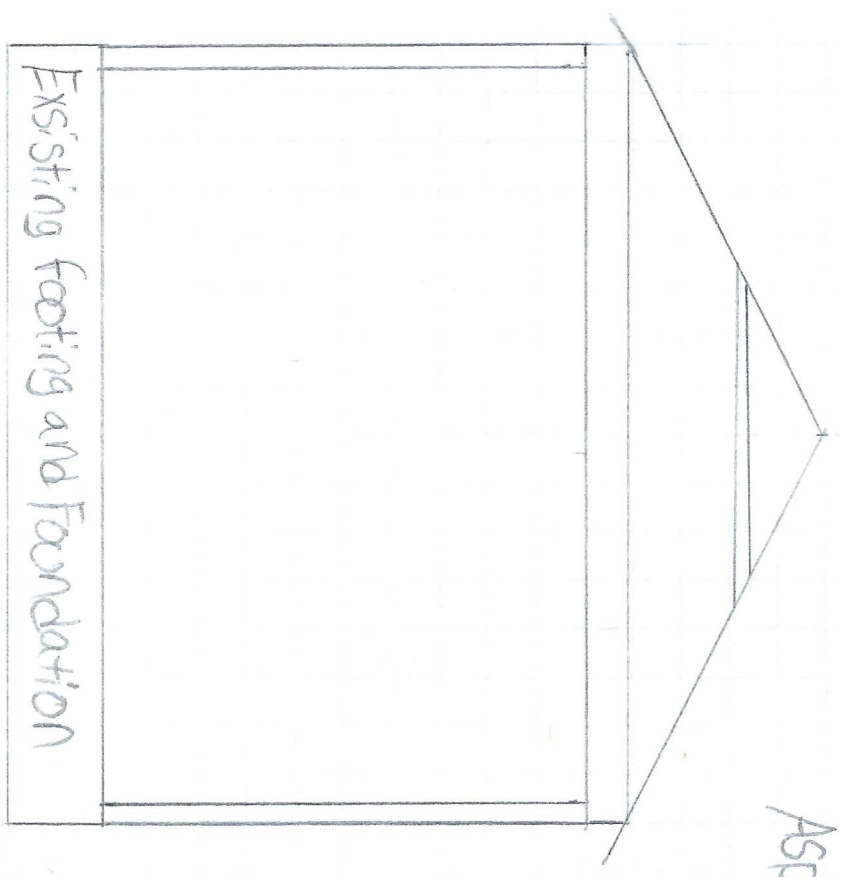
Based on field inspection of existing footings/foundation, engineer review/letter may be required.
